Lower Thames Crossing

5.4.4.2 Draft Agreed Statement of Common Ground between (1) National Highways and (2) Brentwood Borough Council (Clean version)

DATE: October 2023
DEADLINE: 5

E. Work No. 9Z (Sheet 66) – Walking, Cycling, Horse Rider bridge over A127

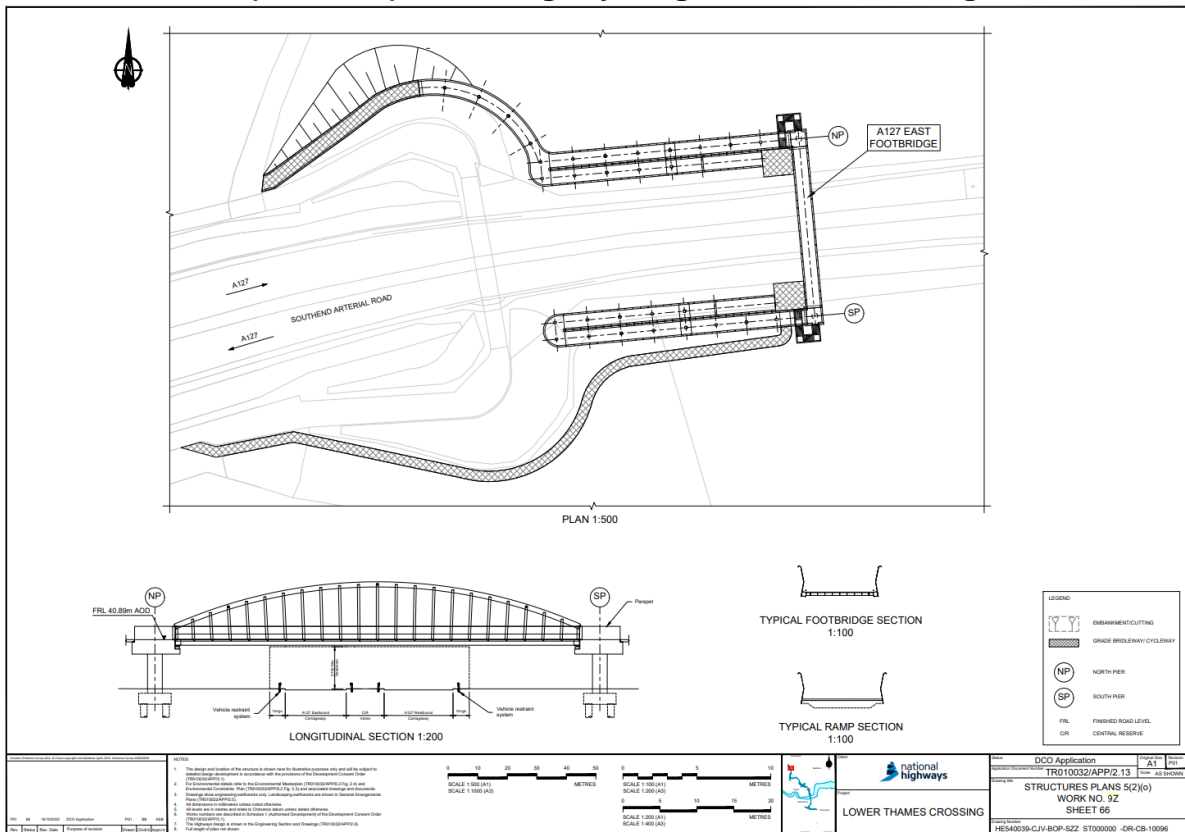
Topic	Item No.	Brentwood Borough Council Comment	The Applicant's Response	Application Document Reference	Status
Active travel – design WCH bridge design)		<p>Corridor Sustainable Transport Vision.</p> <p>1) Instead of a standalone footbridge over the A127 as proposed, this could be incorporated into a multi-user bridge that accommodates pedestrians, cyclists and horses.</p> <p>2) Brentwood Borough Council questions whether the location of the proposed footbridge is appropriate given the above opportunities for multi-use routes and the lack of engagement regarding how it may impact delivery of Brentwood Enterprise Park.</p> <p>There are concerns that the proposals may be incompatible with those being developed through both the adopted Brentwood Local Plan and the current planning application for Brentwood Enterprise Park. The council request that continued engagement is undertaken between National Highways, Essex County Council, Brentwood Borough Council and the Brentwood Enterprise Park promoters, St Modwen. This is to ensure that the most suitable solution is developed in respect of ensuring non-motorised users can cross the</p>	<p>to agree the mechanics of how the two projects will work together to manage their interfaces and have worked closely since the announcement of the preferred route in 2018. The Interrelationships with other Nationally Significant Infrastructure Projects and Major Development Schemes document provides further information on the steps taken by the Applicant to account for its interfaces with other major development schemes.</p> <p>The Project's design will maintain the existing Public Rights of Way (PRoW) connectivity around BEP and enhance its safety. The Applicant has presented and consulted on plans for a new WCH (multi-use) bridge over the A127 east of the existing single-track road bridge into the BEP site to provide these connections and facilitate access from the westbound A127 footway to the eastbound side in order to use the planned upgraded crossings on the north side of M25 junction 29 for connections to/from Havering.</p> <p>The Applicant's negotiations with St Modwen account for their intention to build a northern access road and bridge over the A127 connecting to Codham Hall Lane and junction 29 of the M25 to provide access to the site. This new bridge is located in the same position as the Project's proposed</p>	<p>Council / Lower Thames Crossing BEP meeting 220325 - BEP summary Design Principles [REP4-146] Interrelationships with other Nationally Significant Infrastructure Projects and Major Development Schemes [APP-550]</p>

Topic	Item No.	Brentwood Borough Council Comment	The Applicant's Response	Application Document Reference	Status
		<p>A127 in a safe and convenient manner.</p> <p>As per item 2.1.9, Brentwood Borough Council remains concerned that in the scenario where the LTC scheme is implemented in advance of the BEP proposals that the proposed WCH bridge conflicts with the location of the bridge access across the A127 that is proposed for the BEP scheme. If this was to occur it is highly likely that the BEP proposals would not be able to be implemented which is considered unacceptable to BBC.</p>	<p>WCH bridge ramps over the A127 (Work No 9Z). The existing single-track road bridge over the A127 would be retained and converted for WCH use only with connections to the A127 footways together with the proposed upgraded crossings at junction 29 for connections to/from Havering.</p> <p>The Applicant will continue to promote and seek DCO consent for its design solution as a fallback position to ensure it has a deliverable scheme should BEP not proceed.</p> <p>The Application Documents include an appropriate legal mechanism to allow for the Applicant's solution not being constructed in circumstances where BEP delivers their proposed WCH provision. See Design Principle S14.22 in relation to this WCH provision and the interface with BEP.</p> <p>In the event that the BEP proposal comes forward in place of the new WCH bridge for the Project, there would be no material loss as the enhanced A127 crossing proposed by the BEP application provides the same functionality as the Project's WCH bridge (Work No 9Z). The width of the existing bridge allows it to be retained as a bridleway because the line of travel is more than 2m from the parapet, as recommended by the British Horse Society Guidance. The feasibility of increasing the height of the bridge parapets and infilling the parapets will</p>

Topic	Item No.	Brentwood Borough Council Comment	The Applicant's Response	Application Document Reference	Status
			<p>be looked at by St. Modwen at the detailed design.</p> <p>Brentwood Borough Council welcomes the ongoing discussion. This matter remains under discussion pending evidence that the draft DCO accounts for all scenarios. The Applicant is considering alternative evidence of agreement with the developer, e.g. an exchange of letters, should a commercial agreement not be signed before the end of DCO examination. The Applicant also notes Brentwood Borough Council's request for a drawing to accompany the SoCG illustrating the key bridges and geography around Brentwood Enterprise Park.</p> <p>The 25 March 2022 meeting was positively received by the authorities.</p> <p>Please see item 2.1.9 for a response to how the potential issue with bridge conflicts has been addressed.</p>		
<p>WCH / active travel – design Onward travel of WCH users north of M25 Junction 29)</p> <p>Onward travel of Non-Motorised Users (NMUs)</p>	2.1.12	<p>The Council wants to ensure that due consideration has been given to any necessary improvements for the onward travel of non-motorised users travelling through the northern part of M25 junction 29, and for these to be integrated with mitigations planned through the delivery of Brentwood Enterprise Park and other local plan growth. This is particularly important</p>	<p>Signalised pedestrian and cycle crossings are to be provided on the northern section of M25 junction 29. These will connect to the existing shared use cycle/footways on the northern side of the A127 and located either side of the junction.</p> <p>Improvements to the PRow network have been proposed where this directly relates to the Project to improve connectivity and</p>	N/A	Matter Agreed
